Mountain View Electric Association, Inc. (MVEA) has these comments about the following:

Project Name: Forest Heights Properties

Project Number: MS 206

Description: Forest Heights Estates is designed with four (4) residential lots along with Tracts on approximately 35 acres. This proposed subdivision is located east of Herring Road and north of Shoup Road in Section 09, Township 12 South, Range 65 West.

FOREST HEIGHTS ESTATES FINAL PLAT.

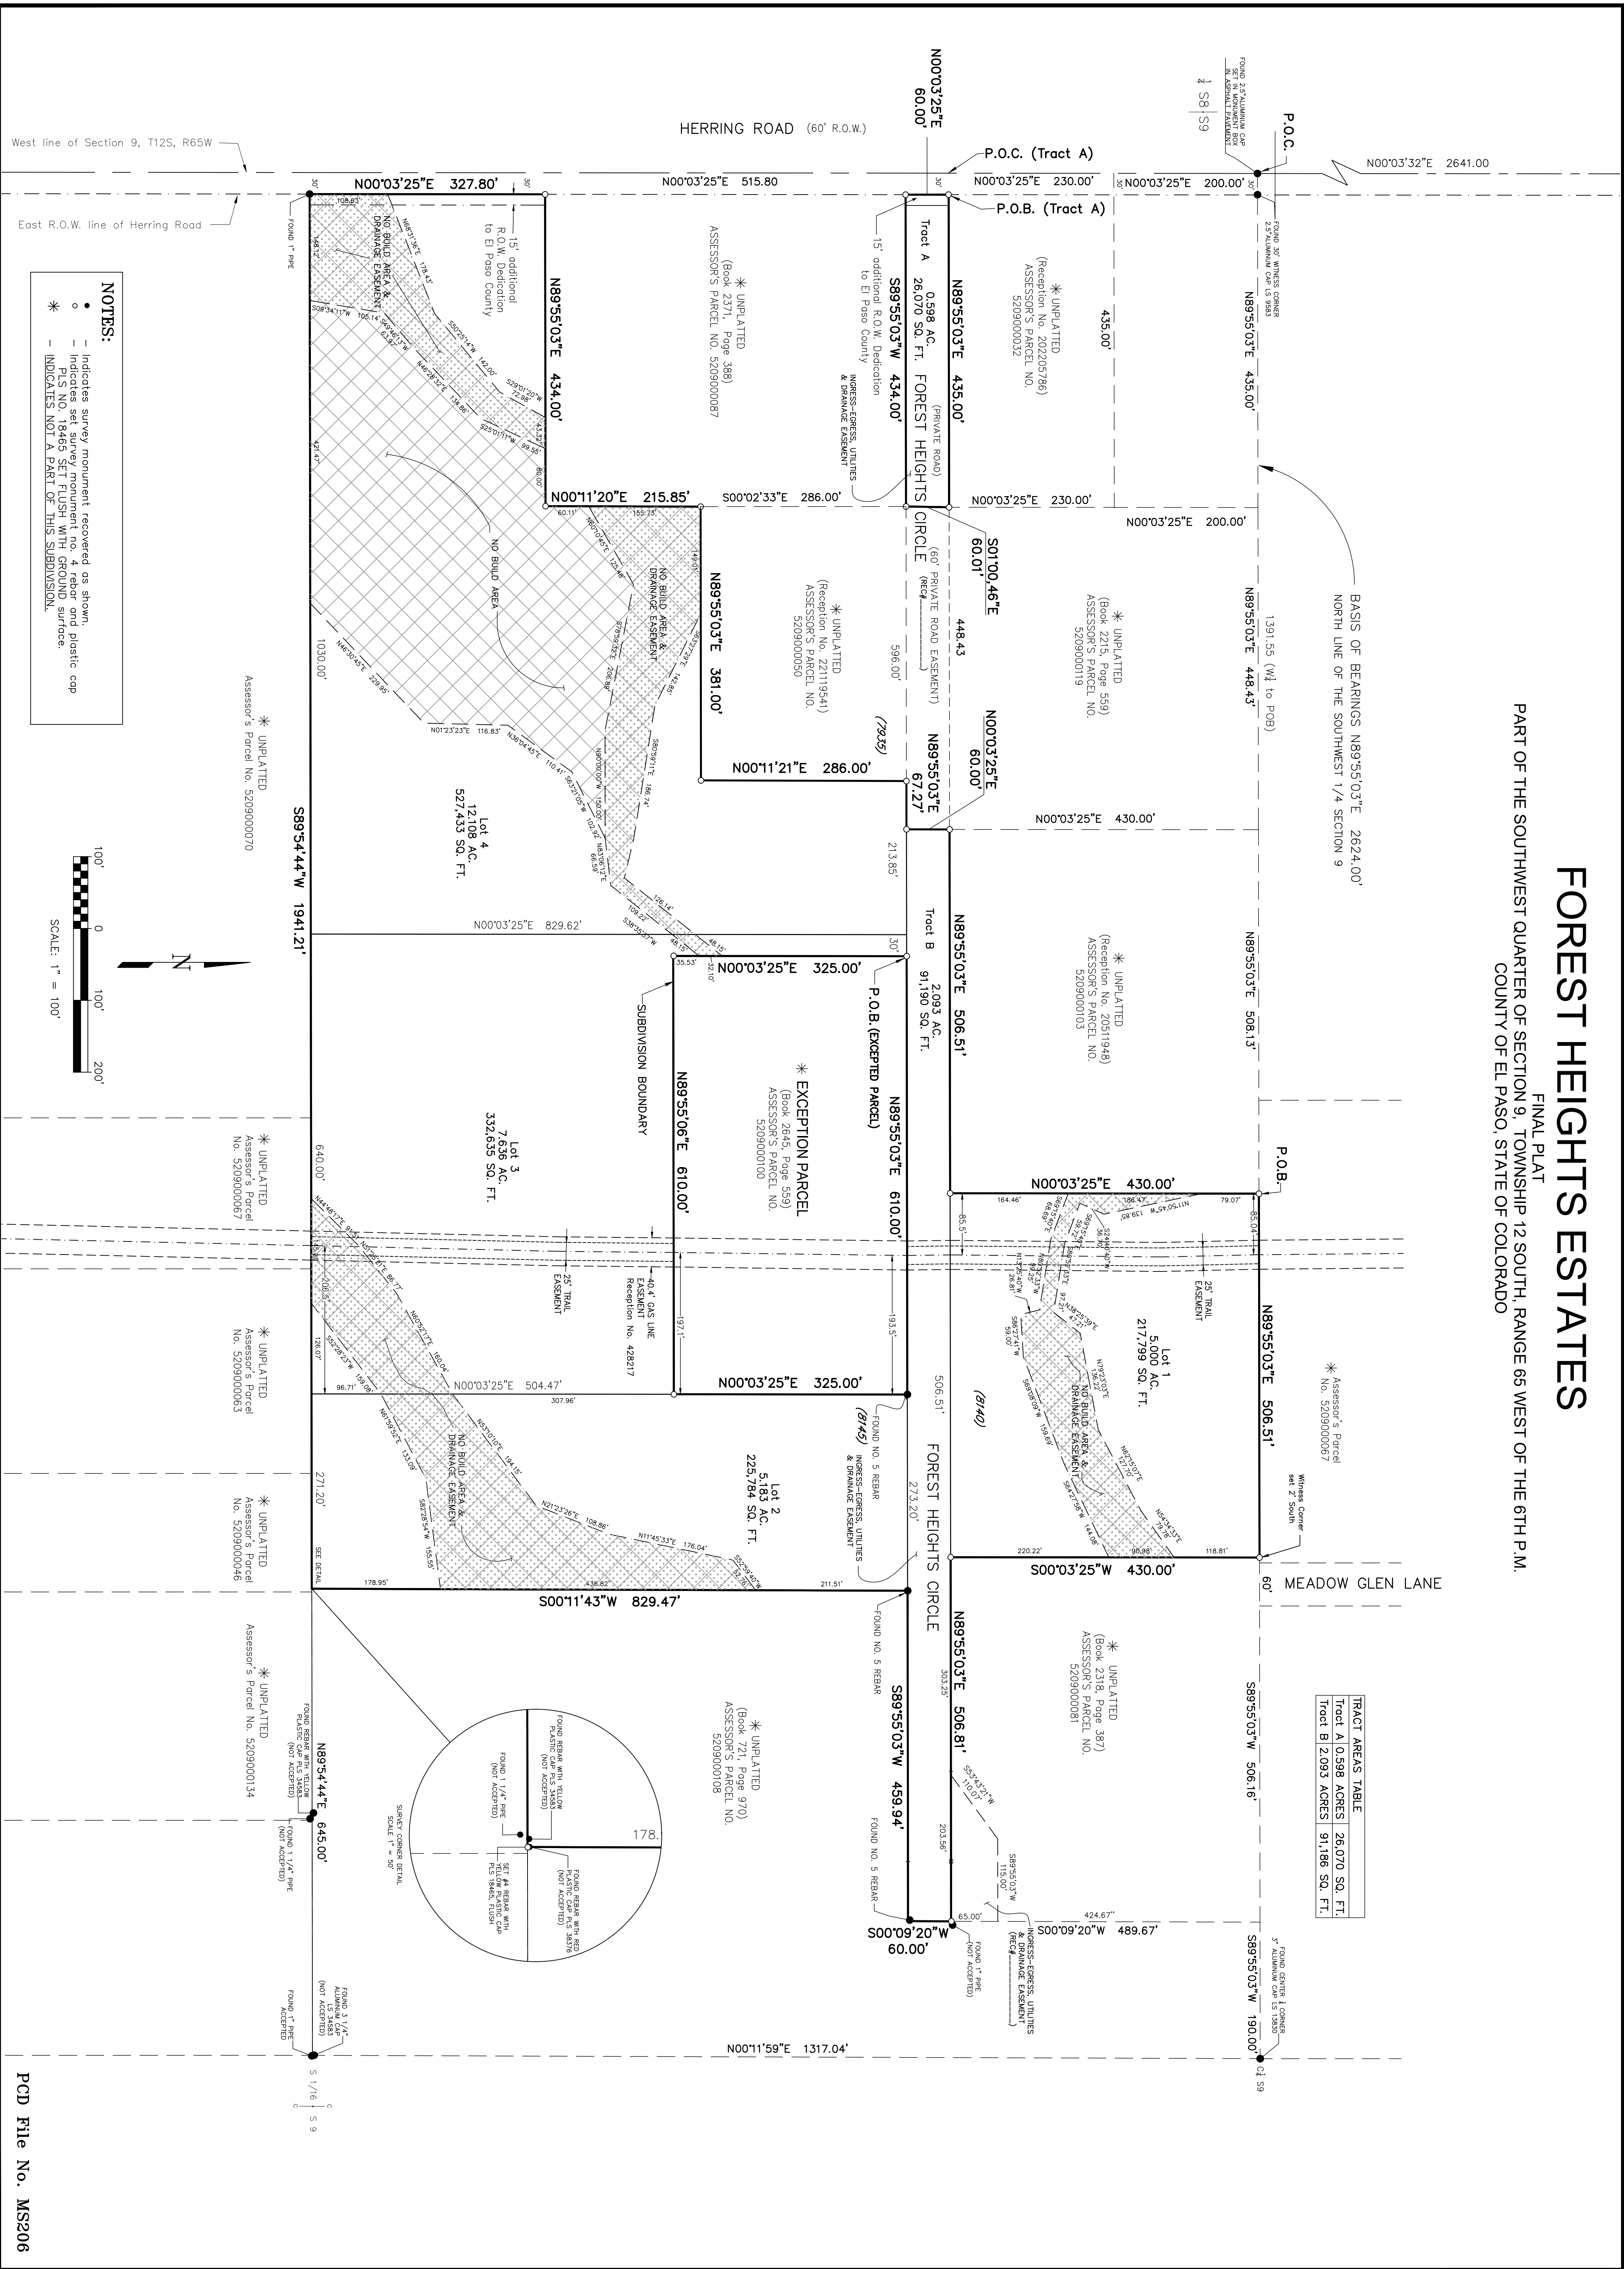
MVEA requests a ten (10) foot front, rear and side lot line utility easement on plat. MVEA also requests platting of existing MVEA facilities with easement on the plat. If drainage, roads and tracts are designed in this subdivision MVEA requests these areas be listed to include utilities.
